From: James Russell
Sent: 05 August 2014 17:24
To: Claire Booth
Cc: Heather Coar
Subject: 3/2013/0539 Whalley Playing fields : Muga, Outdoor fitness area and youth shelter
Importance: High

Environmental Health considers that the proposed MUGA, outdoor fitness area and youth shelter would potentially generate significant uncontrollable noise (ball impacts and shouting from users and potential spectators) affecting nearby dwellings, in particular within their gardens. The development of the MUGA, outdoor fitness and youth shelter will result in an intensification of use. Use during evenings and weekends, when residents would wish to enjoy the amenity of their dwellings, would be likely to generate justifiable noise complaints. Whilst there is an opportunity for noise mitigation to be provided by means of a noise barrier (2m close boarded fence), this is unlikely to mitigate for noise sufficiently. I haven't as yet received an acoustic assessment & management report for this development. The department therefore recommends that the proposed development be relocated to the north of the site (bowling club car park).

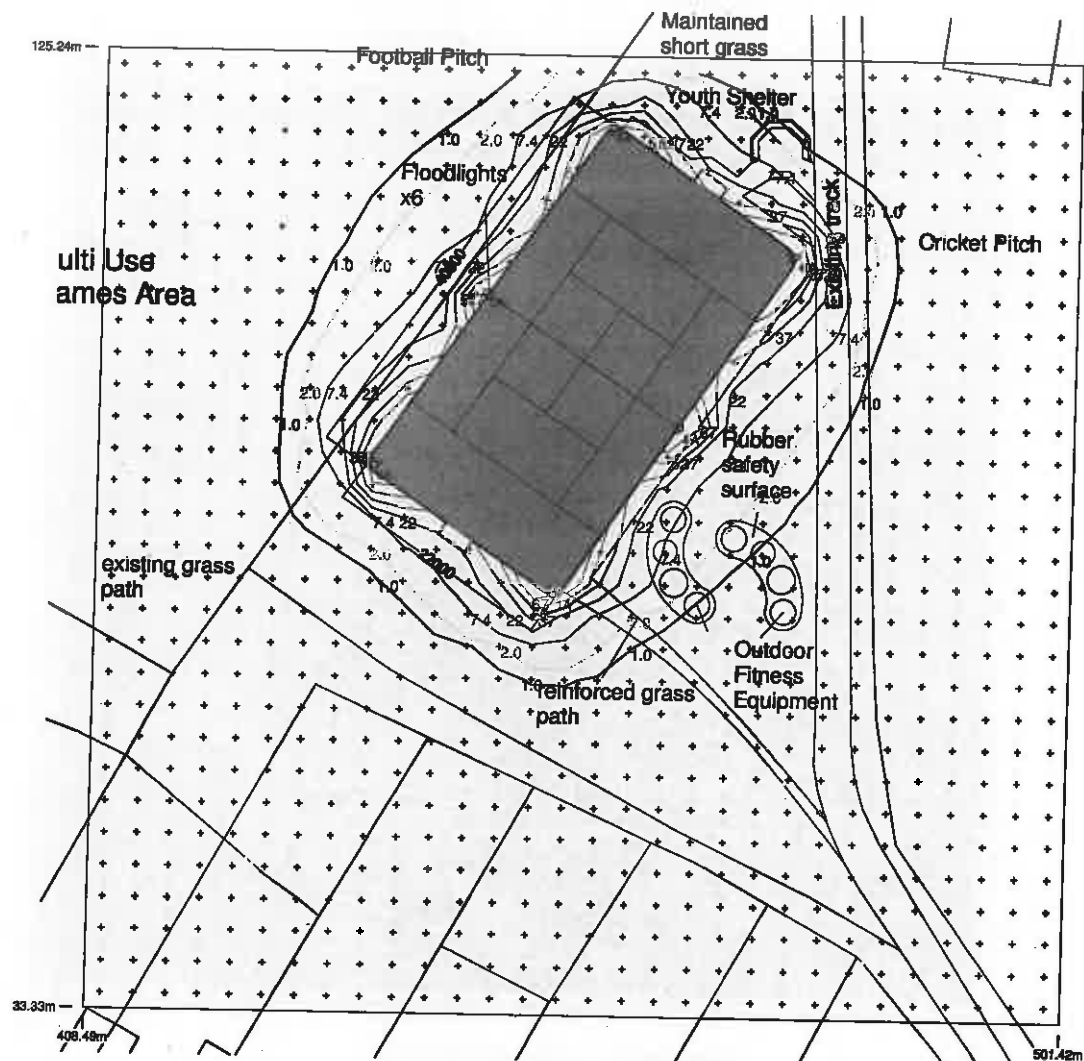
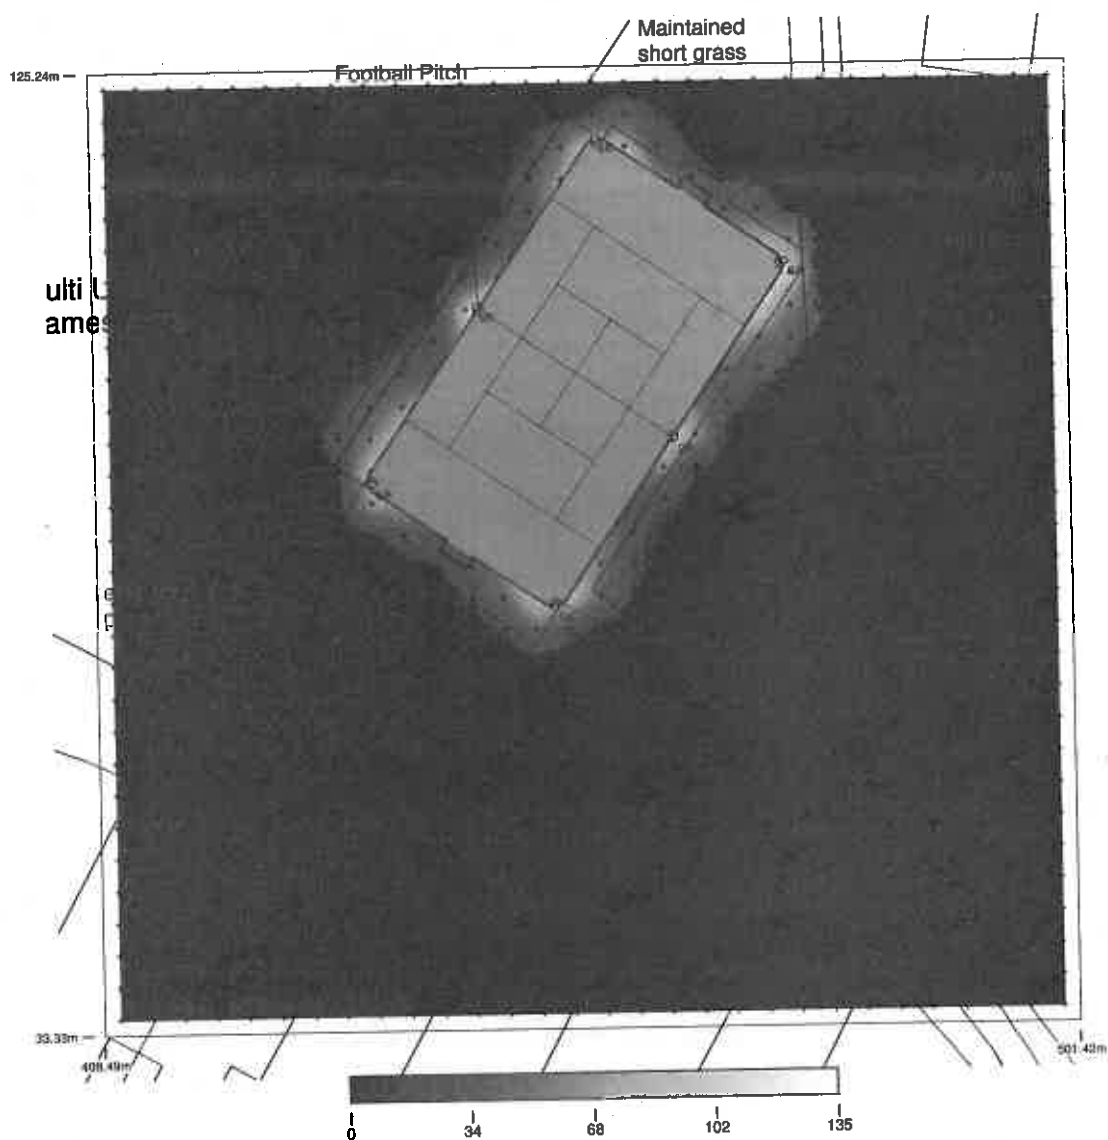
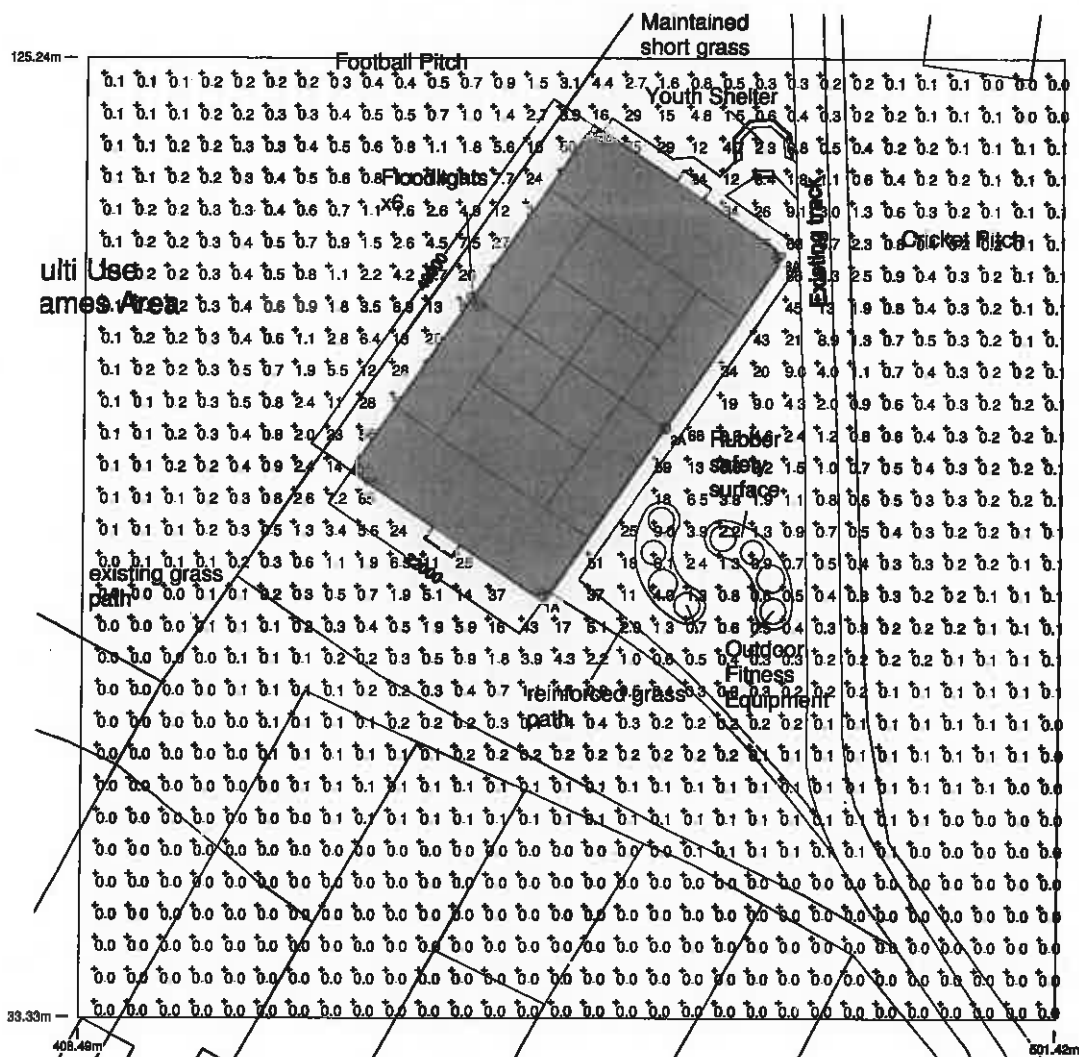
Environmental health has viewed the general area being identified as and falling within Environmental Zone E2 defined as being a low brightness area in a rural, small village or dark urban location. For information, E1 is defined as intrinsically dark landscapes located in sensitive areas such as National Parks and Area's of Outstanding Natural Beauty whilst E3 and E4 zones are areas of medium to high brightness typically small town centres and urban areas and town and city centres.

It is believed that the majority of complaints from local residents on floodlighting installations are not in regard to the amount of light on the property and/or windows but rather their perceived 'brightness' including reflection from the playing surface. It is not feasible to undertake calculations for every possible observer position.

Taking the above factors into consideration the report does not take all reasonable steps to comply with the provisions of CIE 150:2003 – Guide on the limitations of obtrusive light from outdoor lighting .To limit potential light nuisance, the proposed floodlights should comply with current advice from the Institution of Lighting Engineers' "Guidance Notes for the Reduction of Light Pollution". Whilst there is an opportunity for light mitigation to be provided by with a range of baffles and attachments to further alleviate any complaints of glare or perceived 'brightness' .I must note that the report provided for this development , did not allow substantiated evidence of the prevention of the lighting within the documentation provided . The department therefore recommends that an alternative location should be sought.
